Town & Country Planning Act 1990 (as amended)
Town and Country Planning (Development Management Procedure) (England) Order 2015
Approval of details reserved by condition imposed under BE/142/15/OUT relating to conditions 6-
maintenance & management of SUDs system, 11-schedule & samples of materials & finishes, 12-
Construction Management Plan, 13-plan showing phases of development & 22-location of fire
hydrant.

Land west of New Barn Lane Bersted,,

Arun District Council have decided to **REFUSE details reserved by condition for the following reasons:**

Bournemouth Water
South West Water Ltd
REGISTRATION NO 02366655
Peninsula House, Rydon Lane, Exeter, EX2 7HR
Tel (44) 01202 591111
Fax (44) 01202 597022
customerservice@bournemouthwater.co.uk
www.bournemouthwater.co.uk

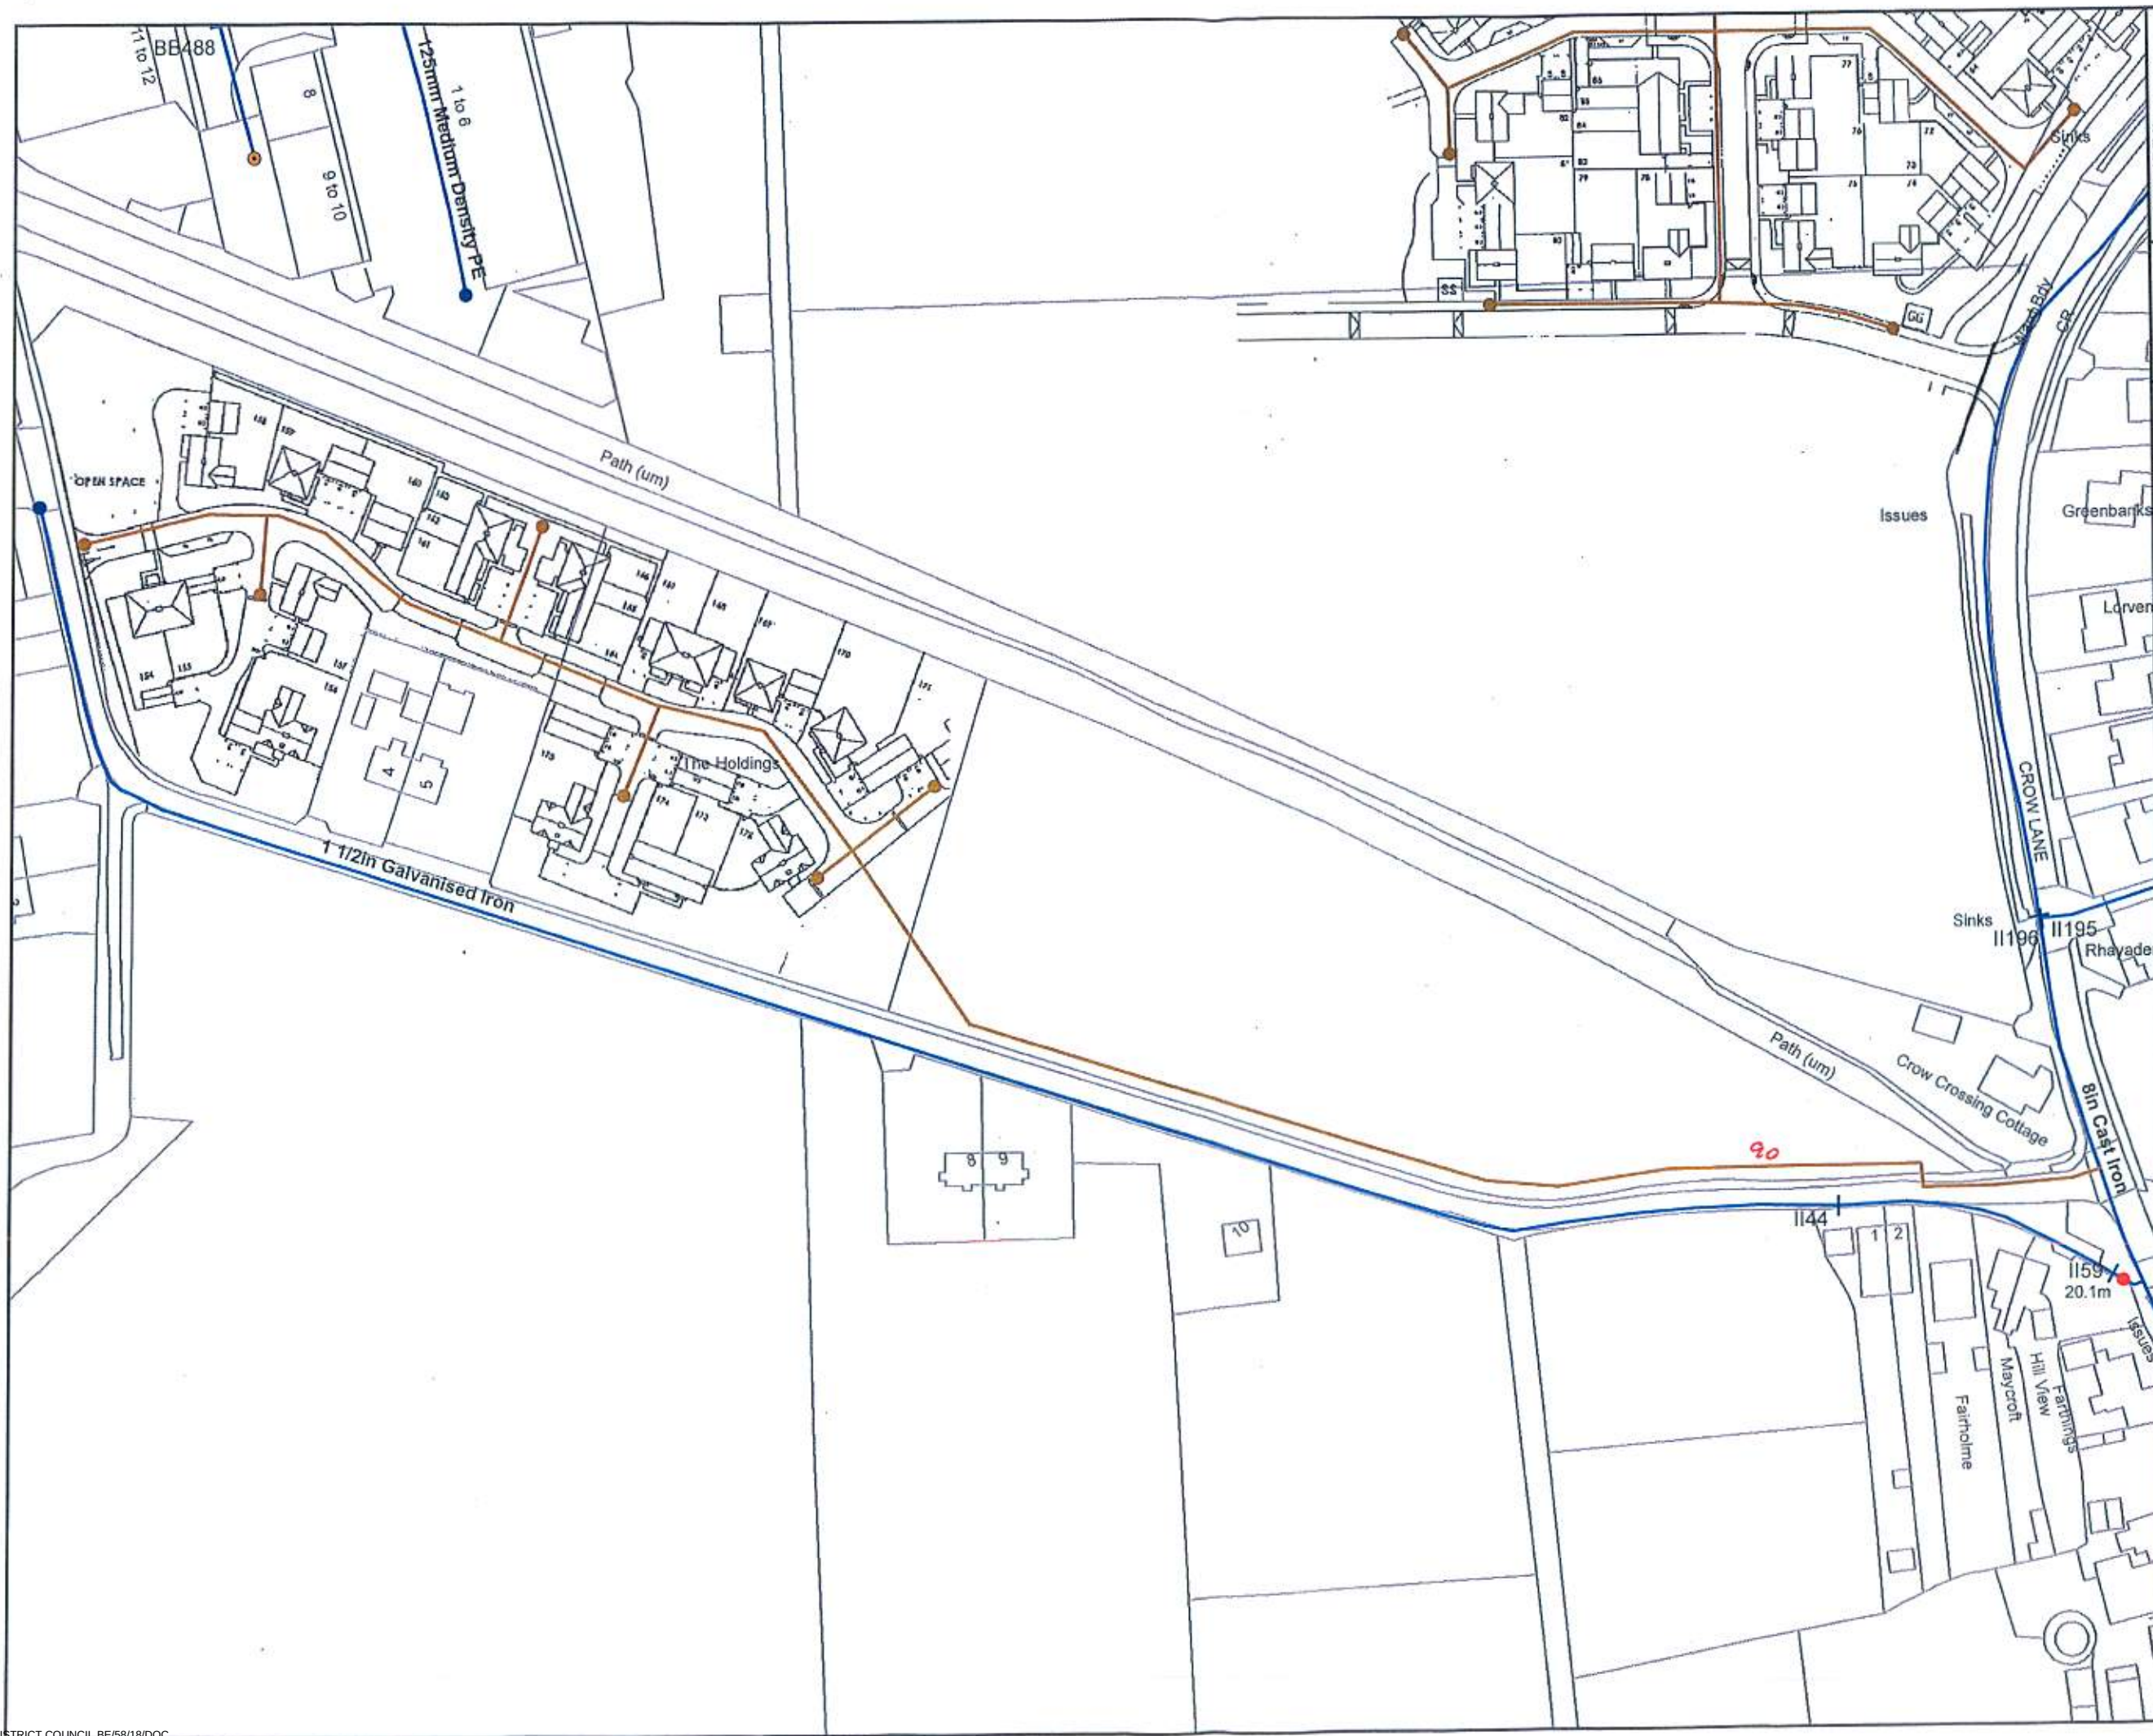
The application to discharge condition 22 is refused on the basis that the submitted plans from 'Bournemouth Water' refer to a site situated outside of the Arun District.
